Subject: FW: Tars Farm BN/41/21/DOC

I am happy for the condition to be discharged providing that external wall construction at the development matches that stated in Table 2 of the submitted report (Ref RP01-201163-R0 by Cass Allen Associates Ltd) and glazing and ventilators at the development match those stated in Table 4 of the same report.

Site Plan showing Measurement Positions (Appendix 2, Figure 1):

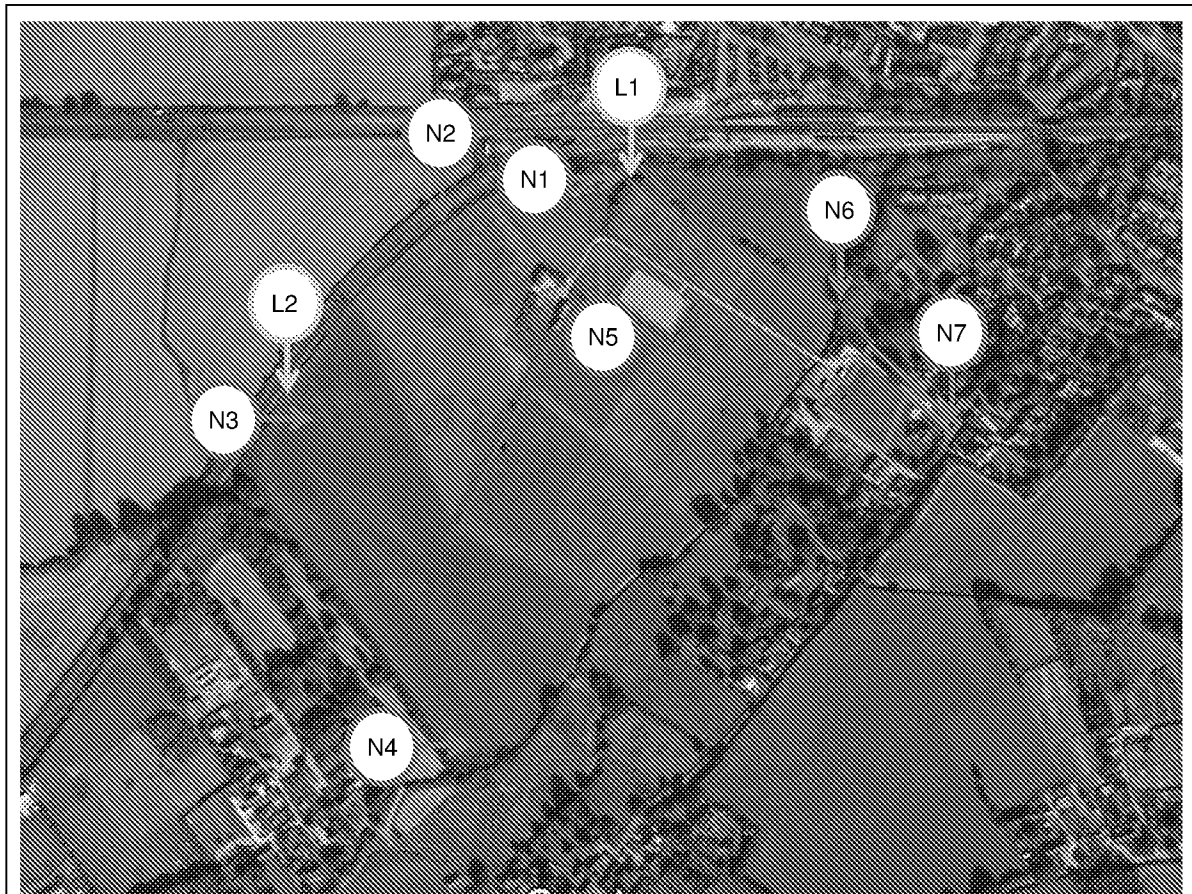
3. Noise survey results at the northern edge of the site relate to the distance corrected values of logged data. Section 3.9 states the noise levels are at a distance of 170m from the nearest railway tracks - nearest dwelling in the development. Logged positions were approximately 3.5m from the track (Appendix 2), assuming the trainline acts as a line source, the noise level will decay by 3dB per doubling of distance. For maximum noise levels, this will decay by 6dB per doubling of distance. The data from logger position L2 was used in our calculations as this was the higher of the two logging results.
